Rodent Farm, AL-19-002

Please accept the following comments from El Paso County Public Health regarding the project referenced above:

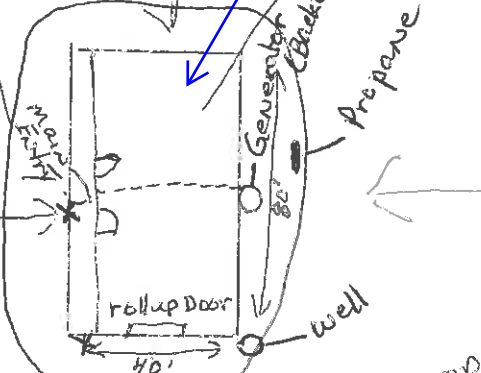
- **The Site Plan Drawing submitted shows a portable toilet onsite. Portable toilets are only approved for temporary use and will not be approved for the commercial use proposed. A Colorado Registered Professional Engineer designed OWTS is required. The design requires El Paso County Public Health review and approval prior to a New OWTS Permit issuance. The design must be sufficient for the 4-employees onsite and any other anticipated wastewater flow from the operation. The design must meet all Board of Health, Chapter 8, Onsite Wastewater Treatment System Regulations.**

- **A secondary site on the property must be reserved for the possibility of a repair, addition or replacement of the required new OWTS soil treatment area.**
